OXFORDSHIRE COUNTY COUNCIL'S RESPONSE TO CONSULTATION ON THE FOLLOWING DEVELOPMENT PROPOSAL

Application No: 17/02006/REM

Proposal: Reserved Matters application to 10/01642/OUT - 21 plots within the B3 parcel following on from approved reserved matters application 15/01209/REM

Location: Heyford Park Camp Road Upper Heyford Bicester OX25 5HD

SITE		PARCEL B3	
		UPPER HEYFORD	
DRAWING TITLE			
PARKING STRATEGY			
PLOTS 199-200 & 226-244			
DRAWN BY	DATE	DRAWING NO.	REV
CW	27.05.15		
SCALE	CHECKED/DATE	APP2-02-281	
1:500

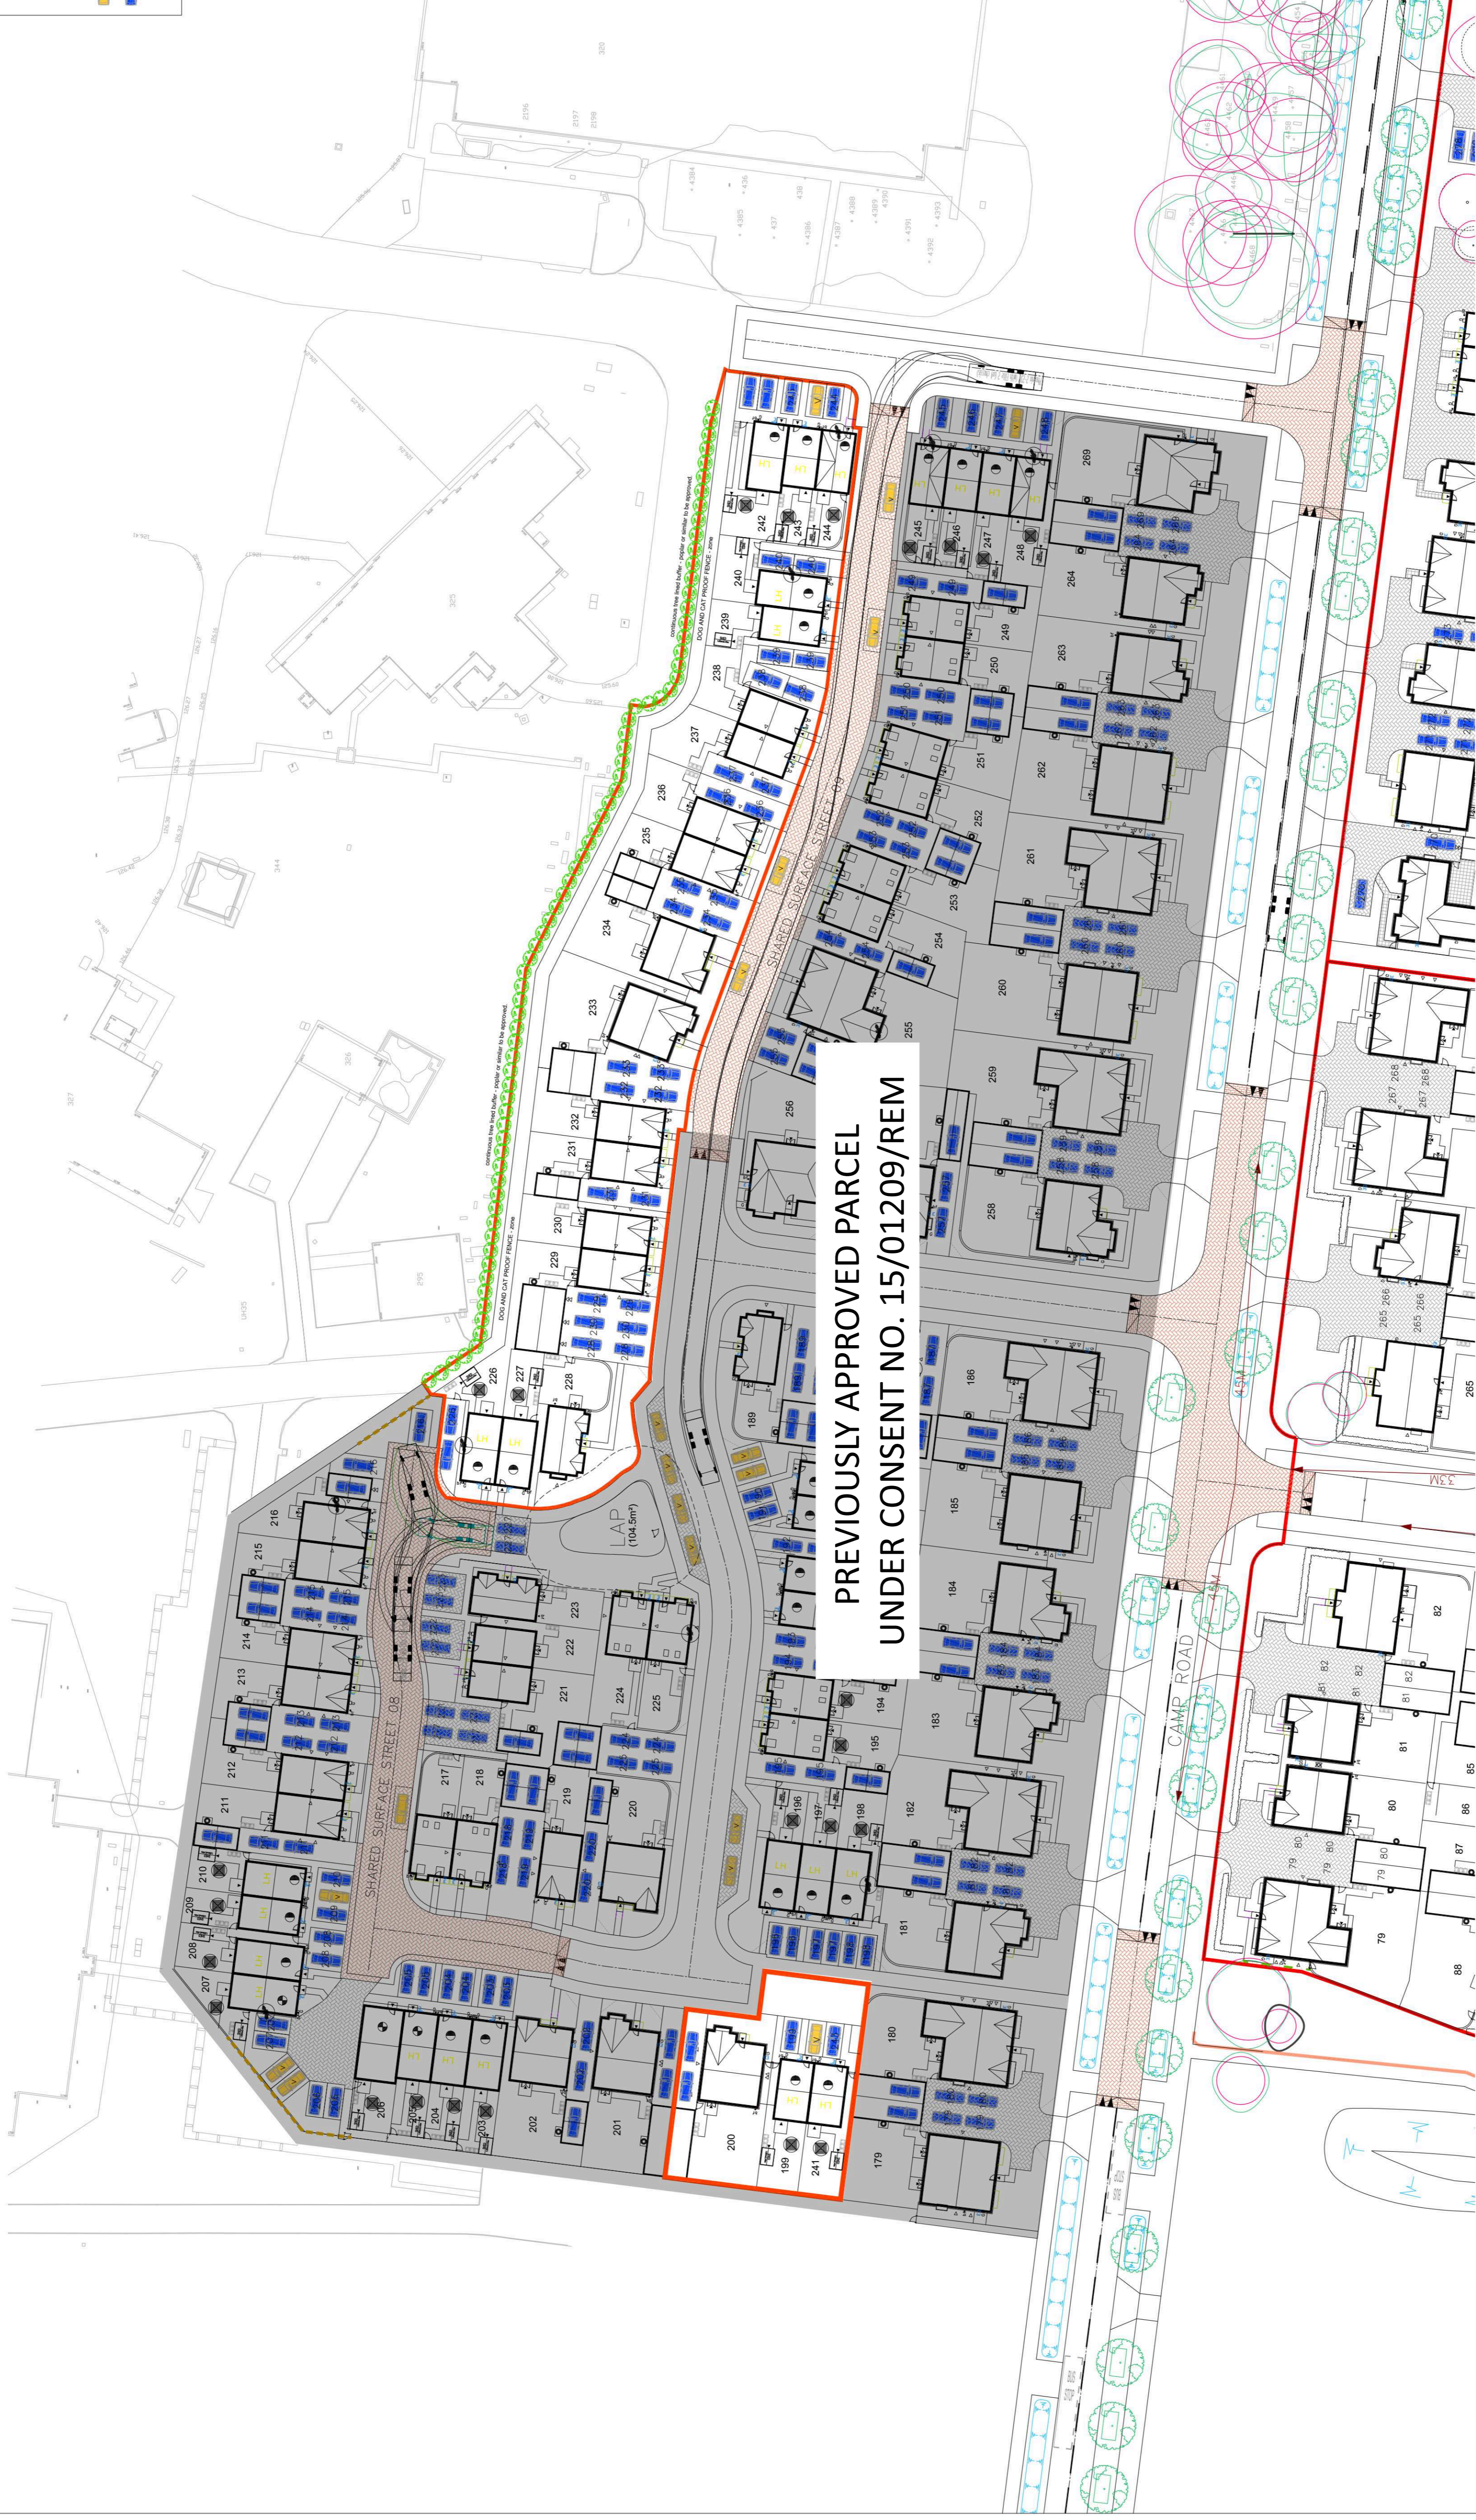
Parking provision presented on drawing No.UPP2-02-281 meets the standards set out in the Heyford Park Design Code. However, the following discrepancies should be noted.

- The two private parking spaces outside plot 242 are not allocated, and this plot therefore has no allocated parking.
- The two private parking spaces allocated to plot 277 are outside the red line.
- The private parking space outside plot 241 is allocated to plot 243, and this plot therefore has no allocated parking.

These items should be rectified on a revised Parking Strategy plan to be submitted in discharge of a condition of planning permission.

Details: **PROPOSED ENGINEERING LAYOUT SHEET 3**

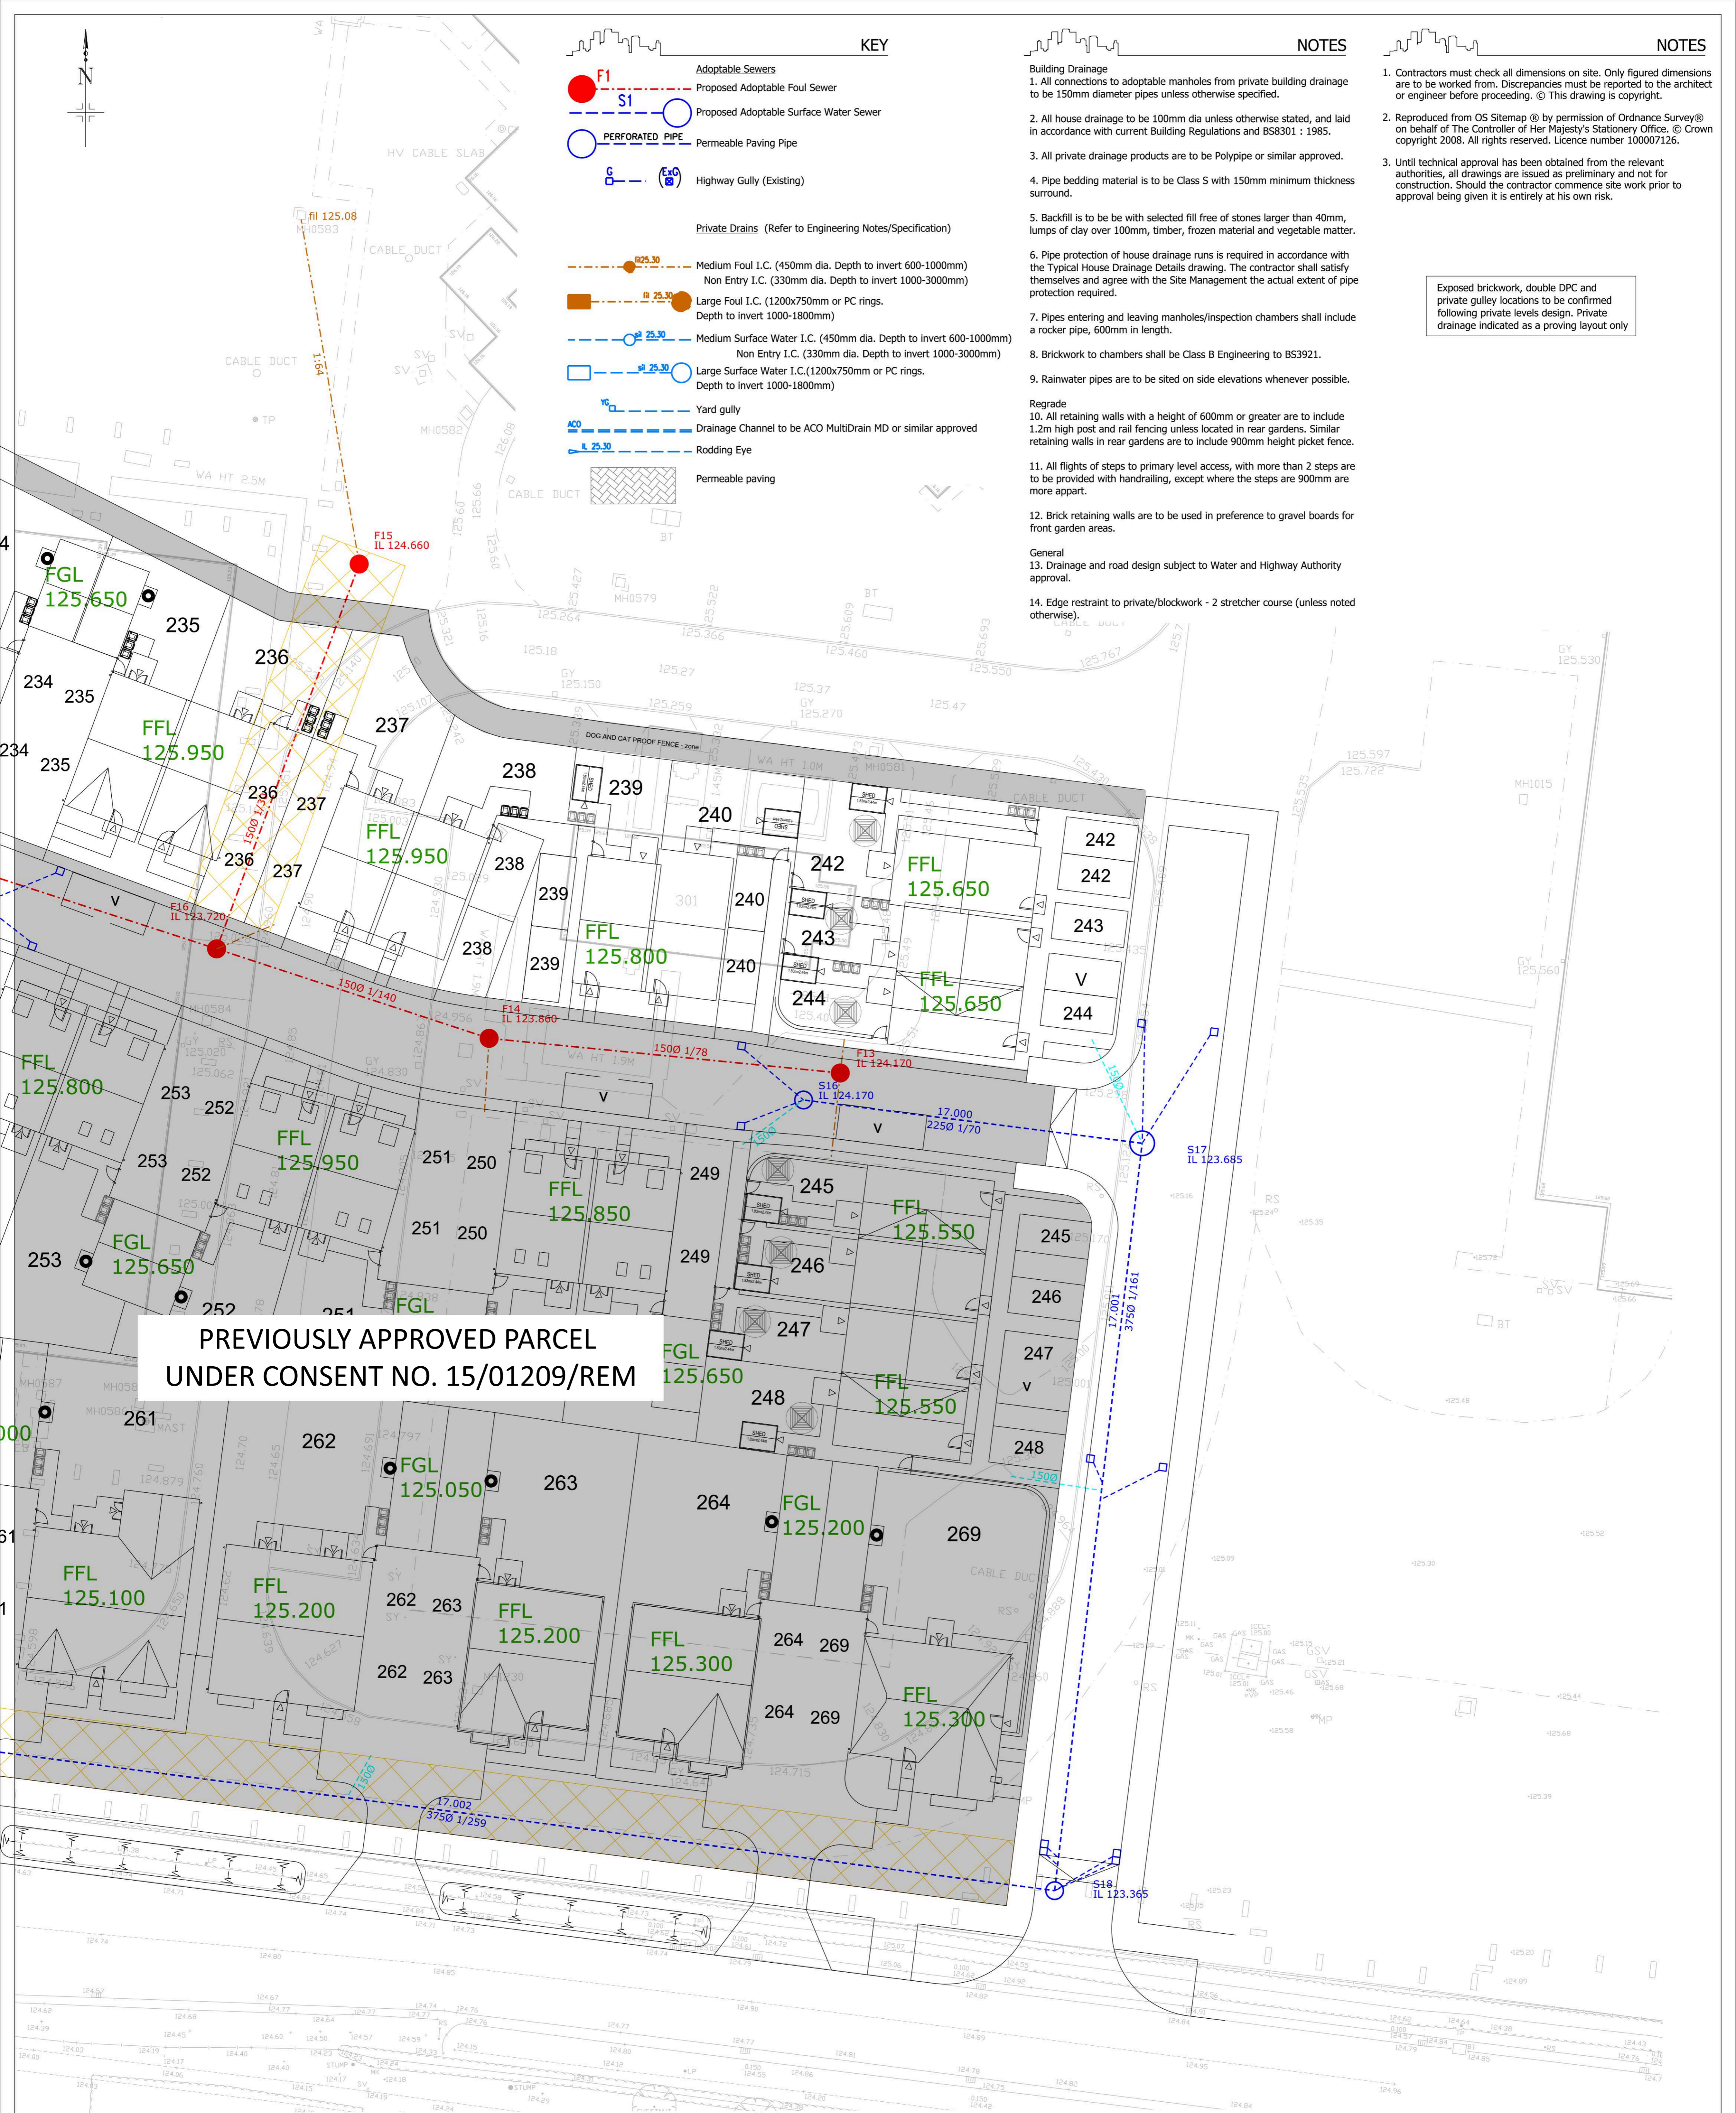
OCC Drainage raises no objection to this reserved matters application. However, there is concern as the use of permeable paving at the site, as shown on the applicant's submitted drawings, appears limited in extent. Permeable Paving plays a role in the treatment train process of improving water quality, through a process of water filtration. There is opportunity for the greater use of permeable paving at the site, for example in the private parking bays/ parking areas.
